**Consultation Response from KC,
Growth and Regeneration**
2022/92724 30, Church Street, Dewsbury, WF13 1LB
Prior notification for the change of use of upper floors to 16 apartments
Date Responded: 27th September 2022
Responding Officer: MI
Responding Ref:

**DRAWING NUMBER / REVISION:**  
22/FGH001/008(A) Revision B

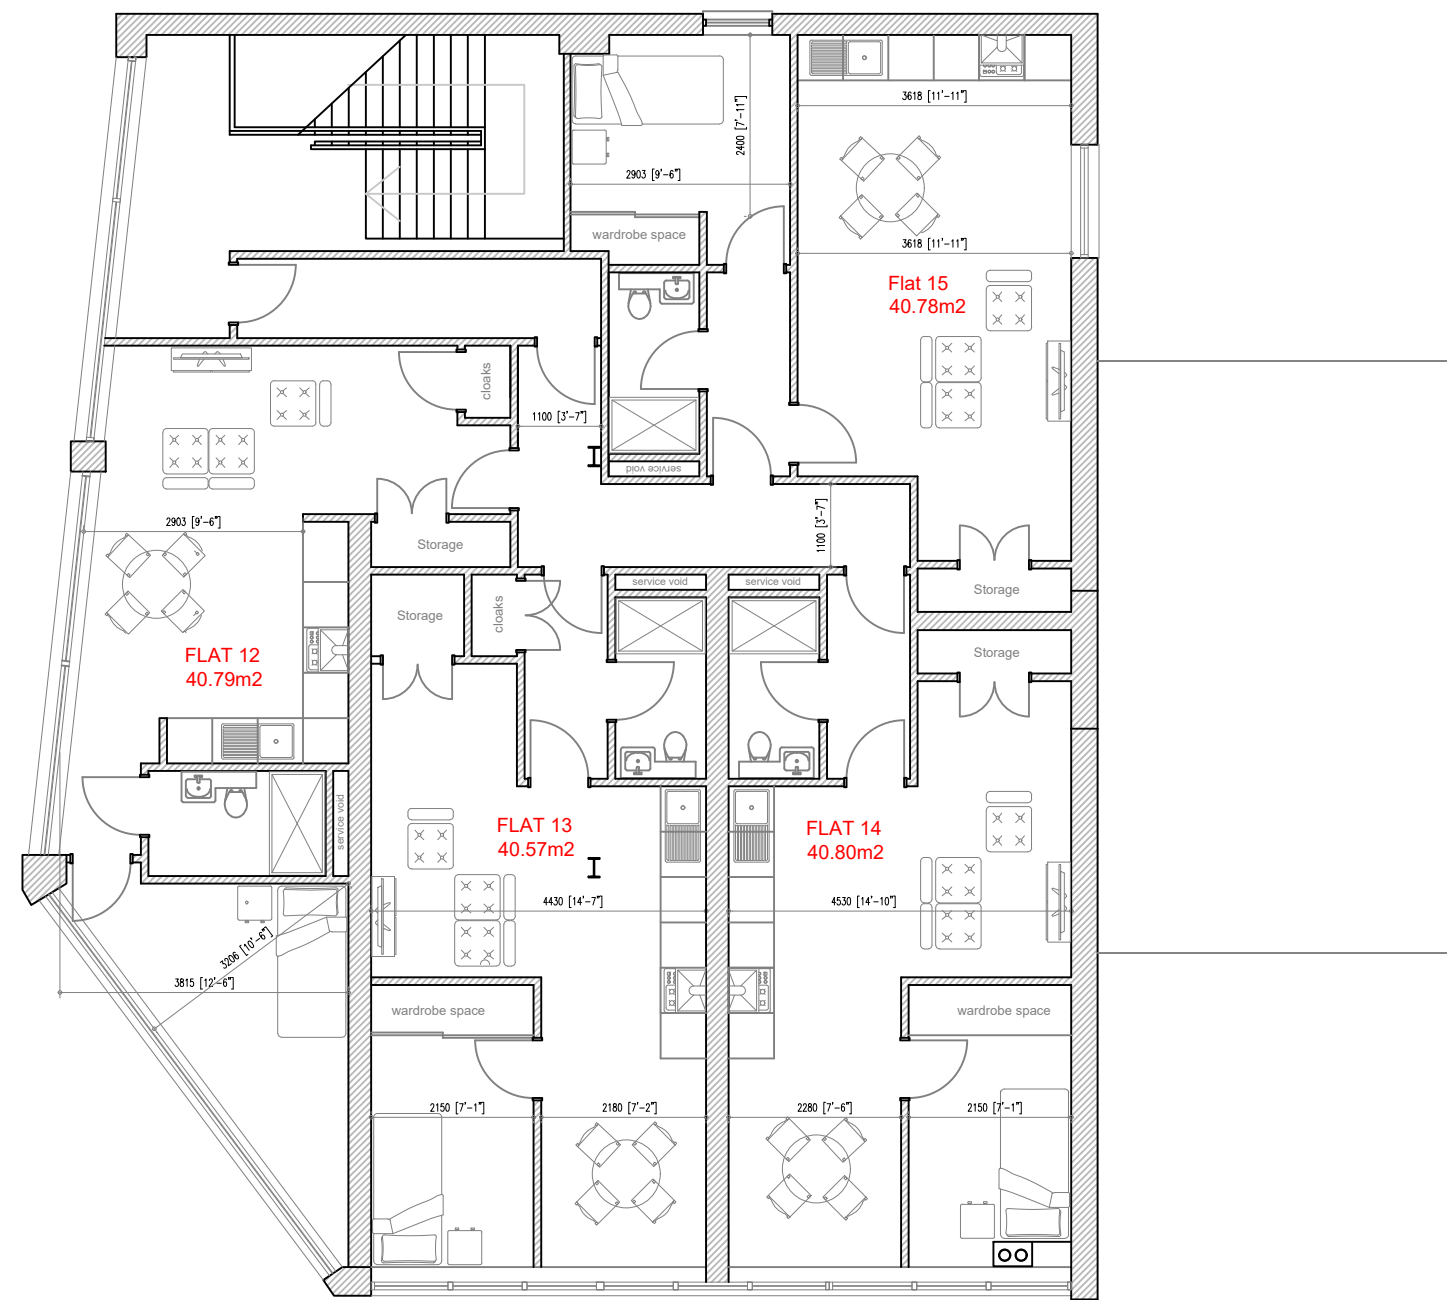
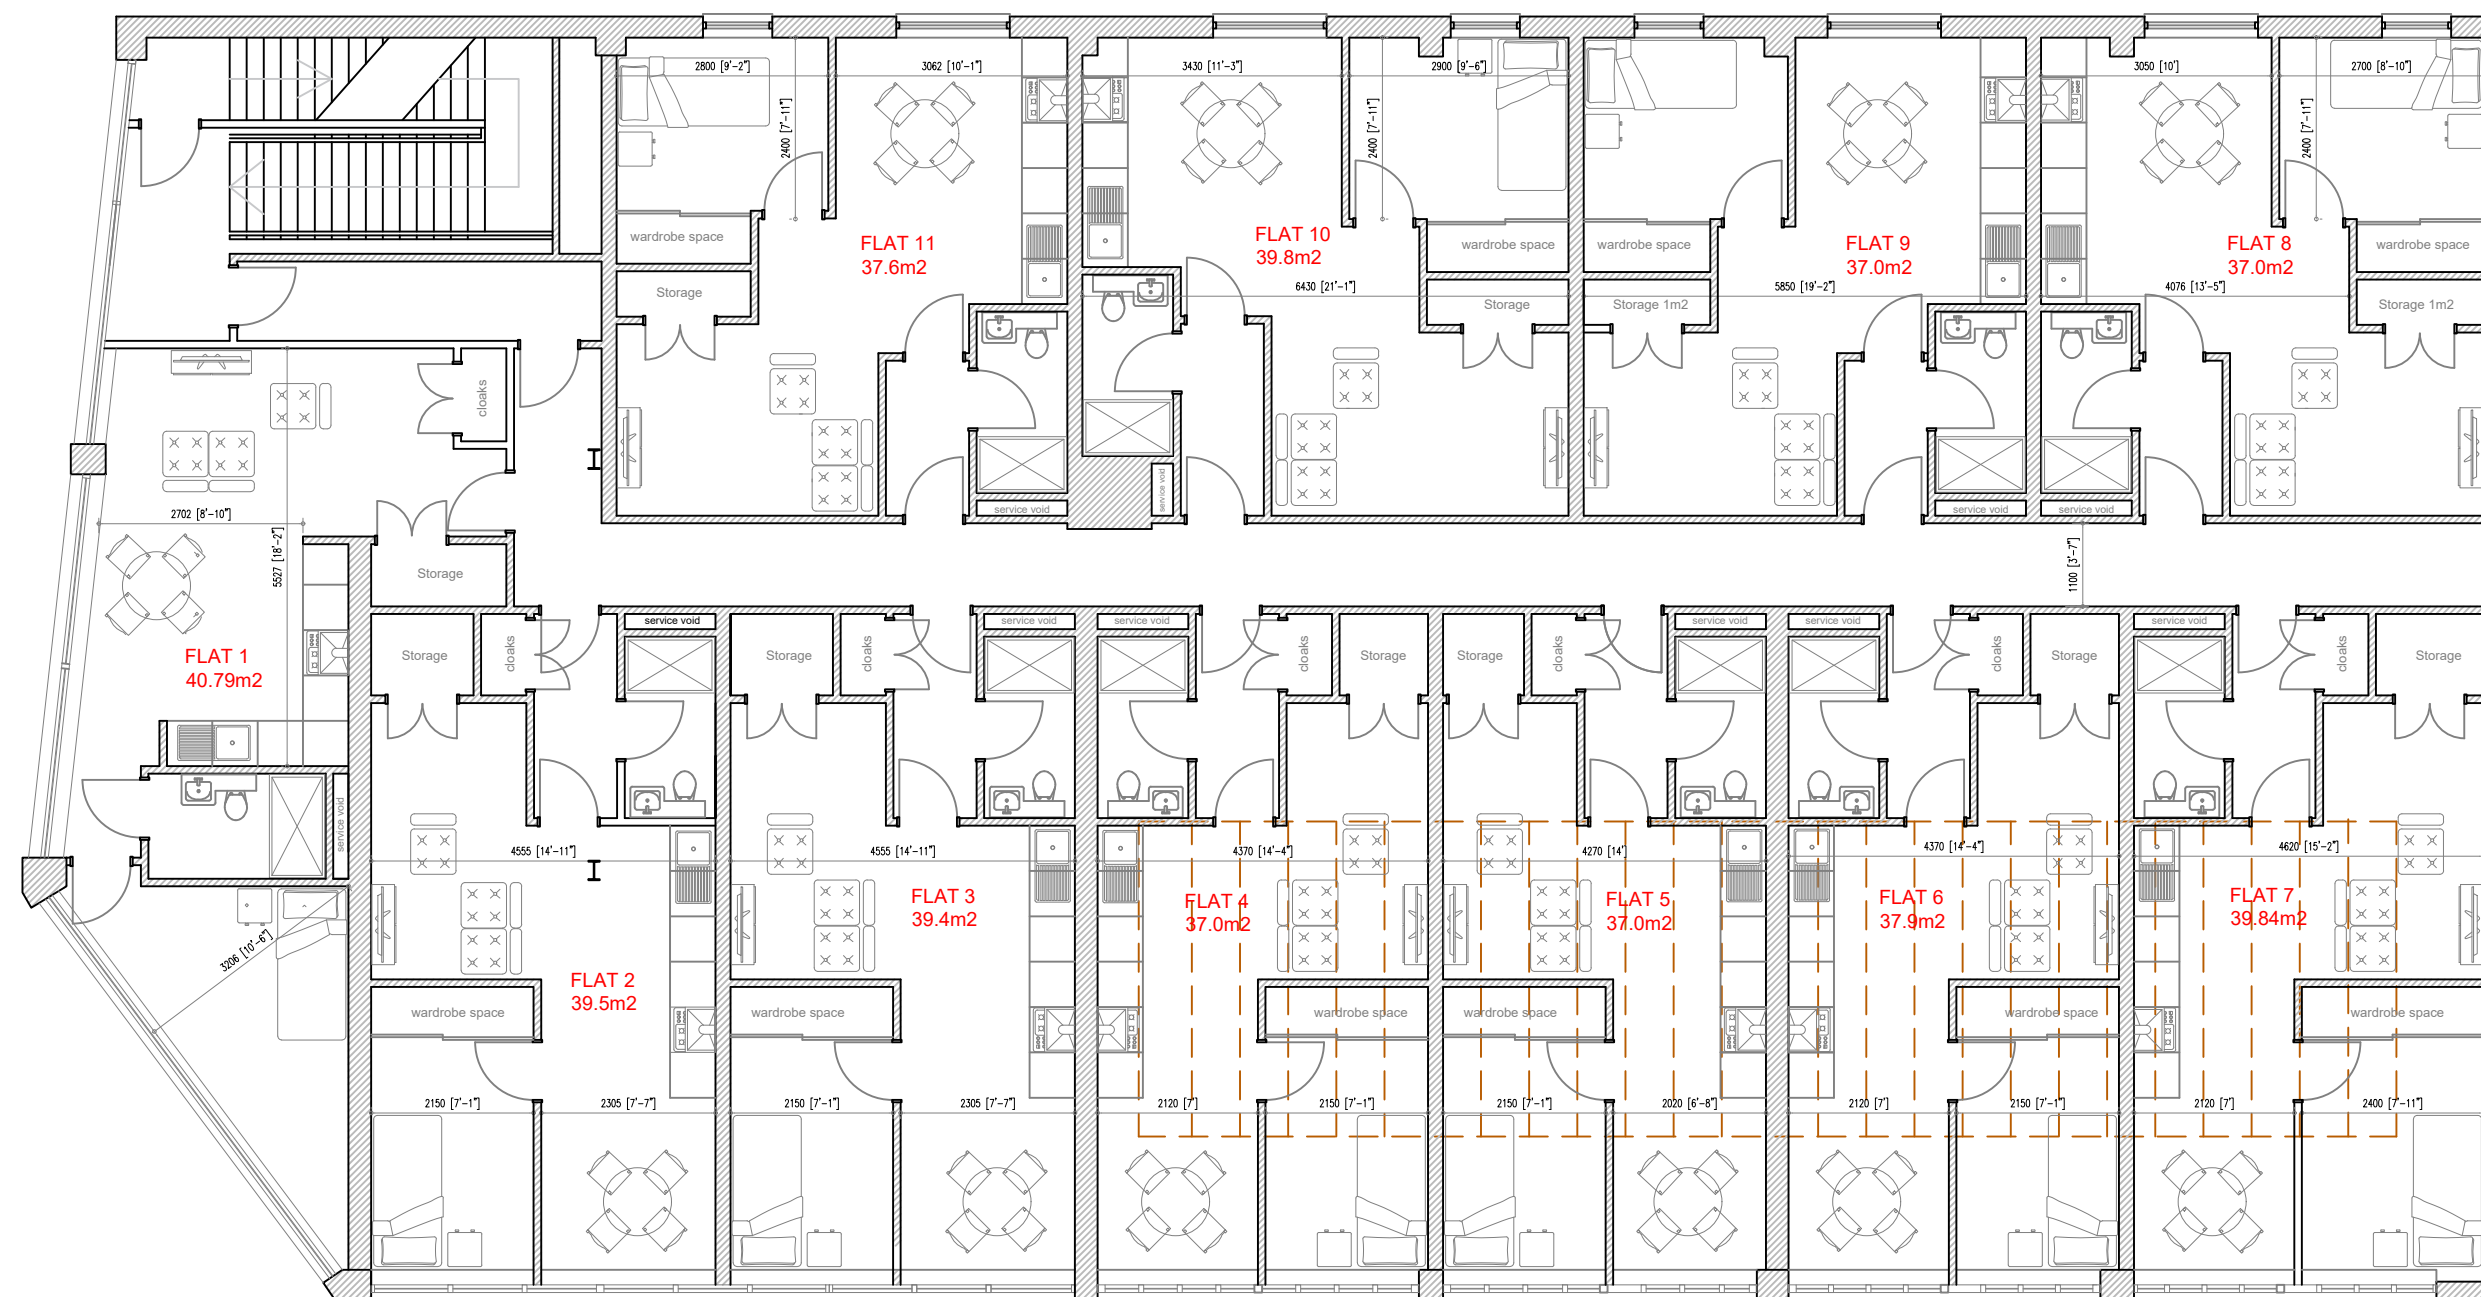
- Drawing No 22/FGH001/008 (A) shows that the existing windows will be retained to allow natural light in all habitable rooms. The plans however note the windows are on the elevation where the bedrooms are being proposed. It is unclear as to how the other habitable spaces in the building will gain from natural lighting.
